City of Albuquerque

RE: ENGINEER'S CERTIFICATION FOR QUANZ CAR CARE (C12/D5)
RECEIVED FEBRUARY 23, 1994 FOR CERTIFICATE OF OCCUPANCY APPROVAL
ENGINEER'S STAMP DATED 2-21-94

RE: GRADING & DRAINAGE PLAN FOR QUANZ CAR CARE (C12/D5)
ENGINEER'S STAMP DATED 9-23-93, RECEIVED SEPTEMBER 24, 1993
FOR WORK ORDER APPROVAL.

GRADING & DRAINAGE PLAN

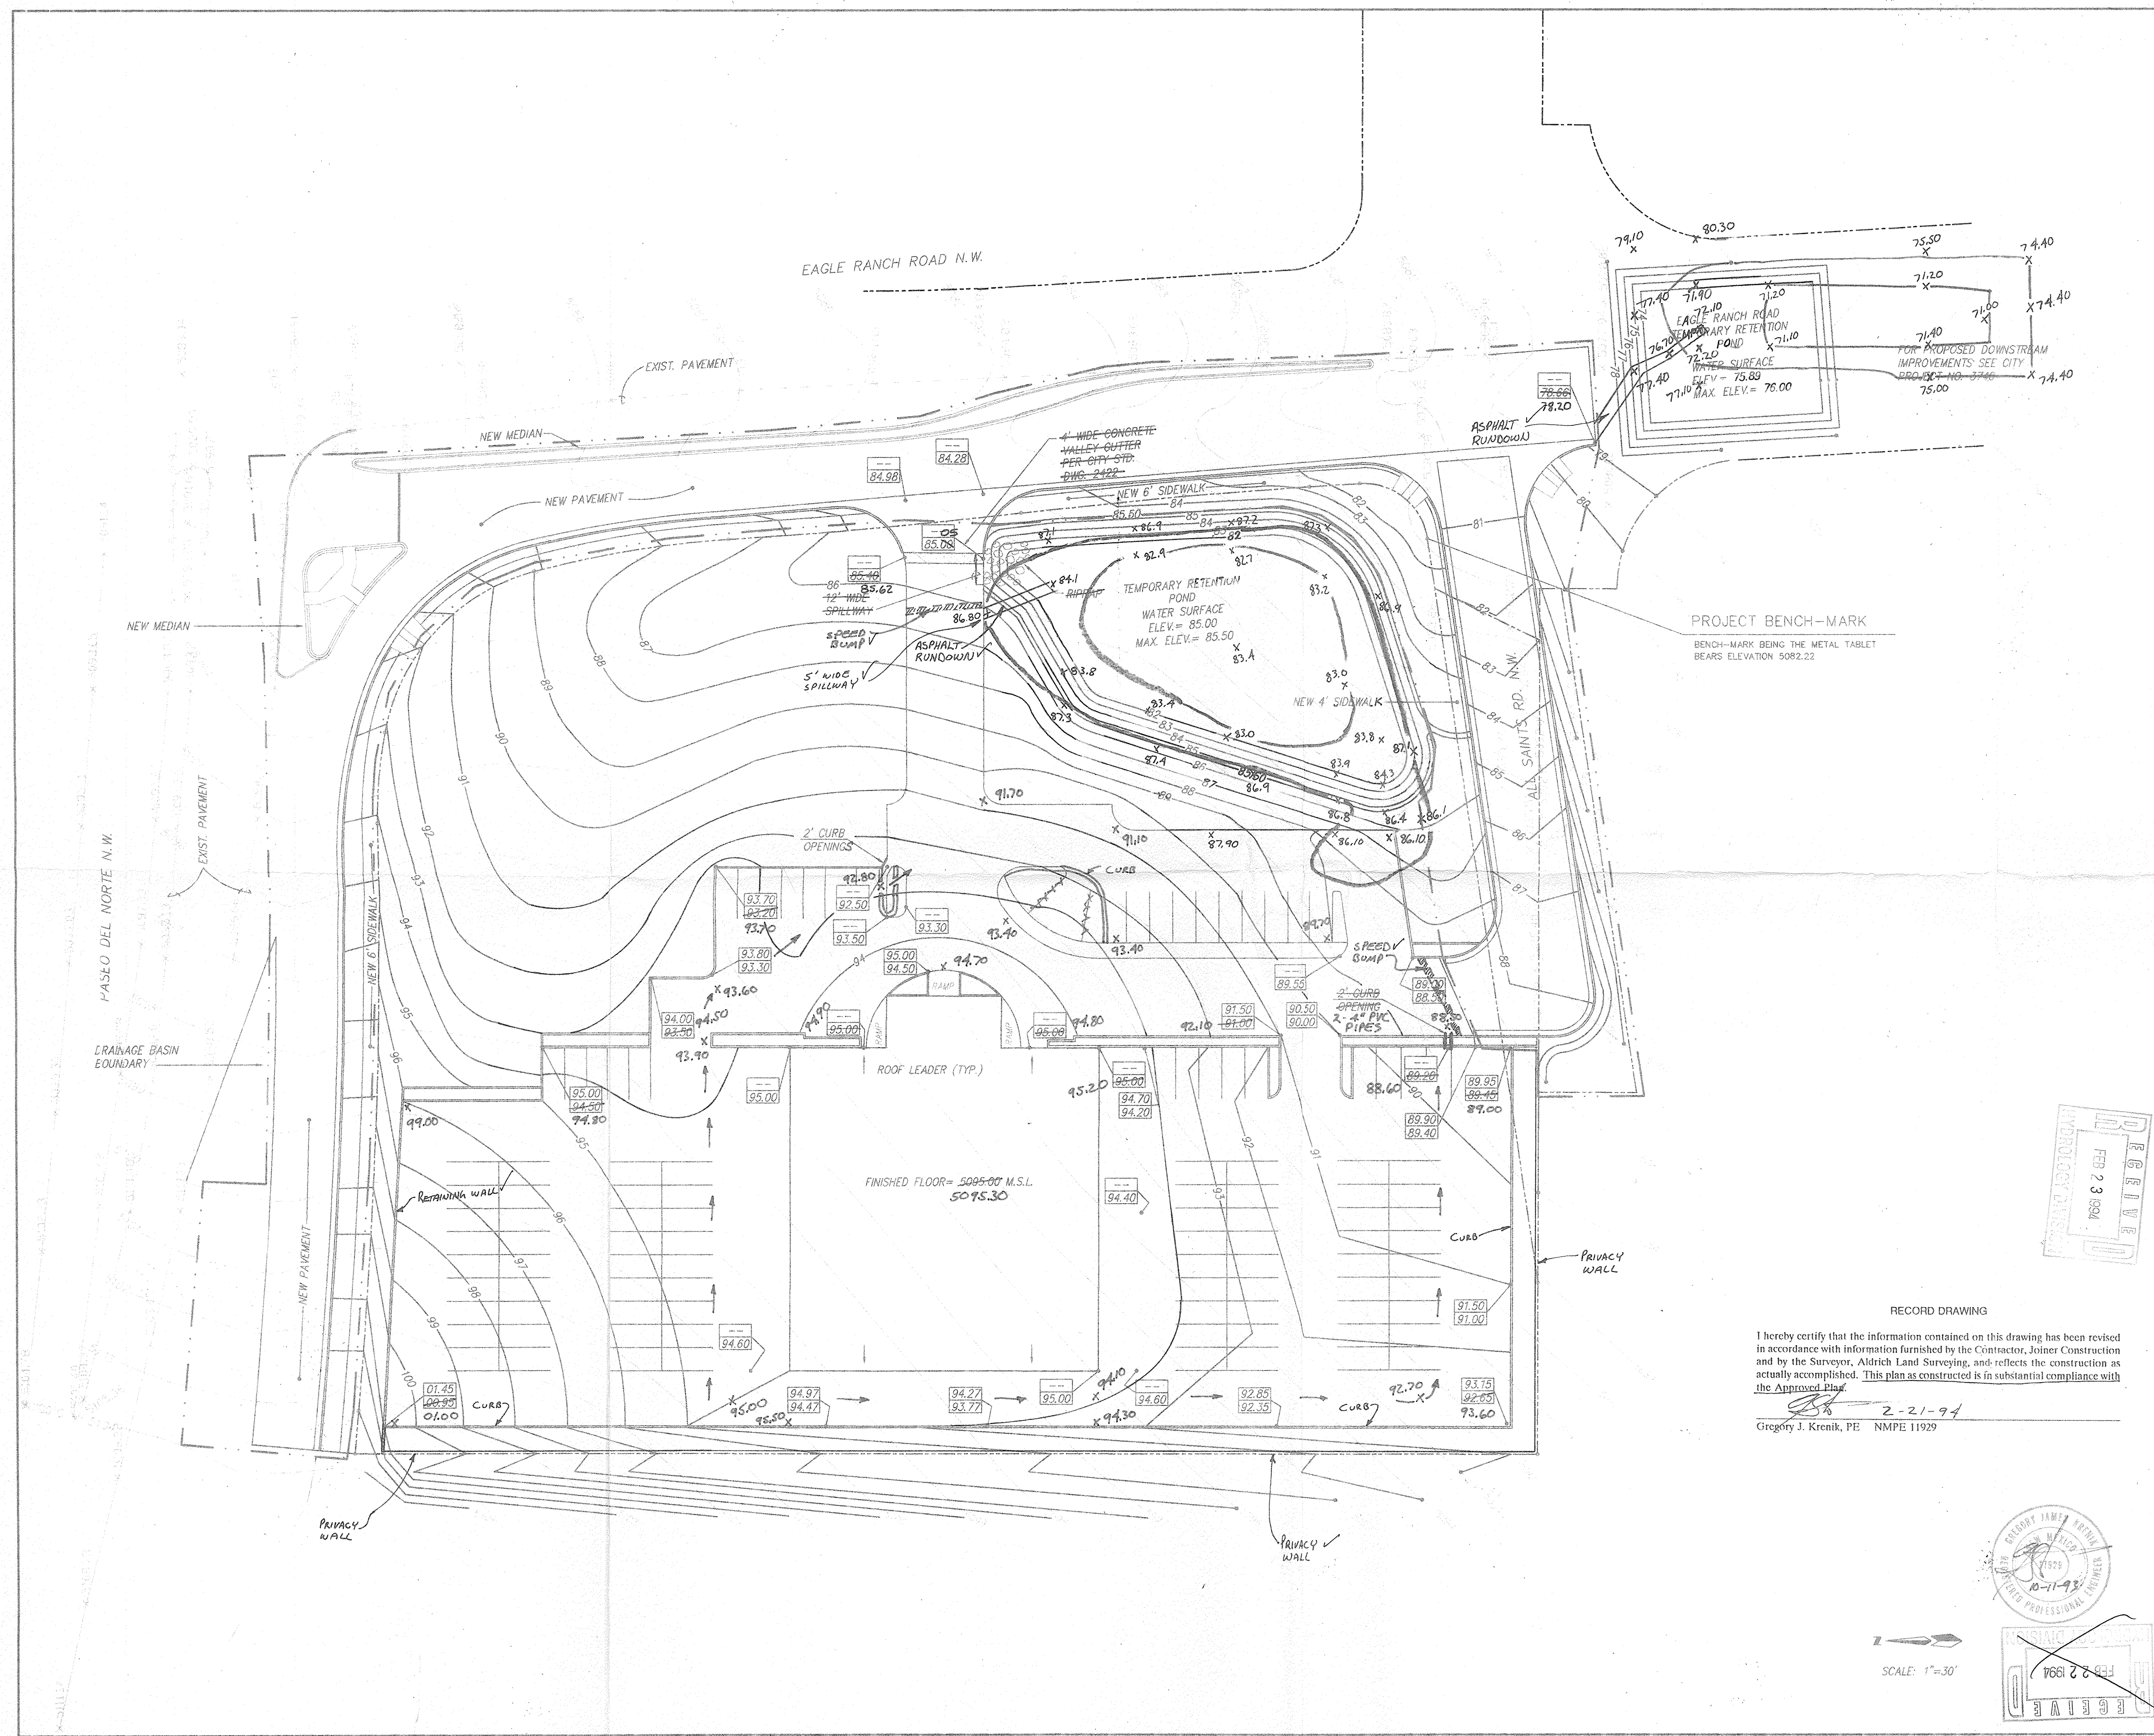
1. Letter from Norm Gregory dated August 18, 1993 does not mention grading a swale on his property.
2. Any retention pond constructed with a berm must have an emergency spillway designed to convey the 100-year peak flow per the Mayor's Emergency Rule published 5-14-91. Also, Retention pond volume must be based on the 100-year/10 day storm or 2 x 100 year/6 hour storm.
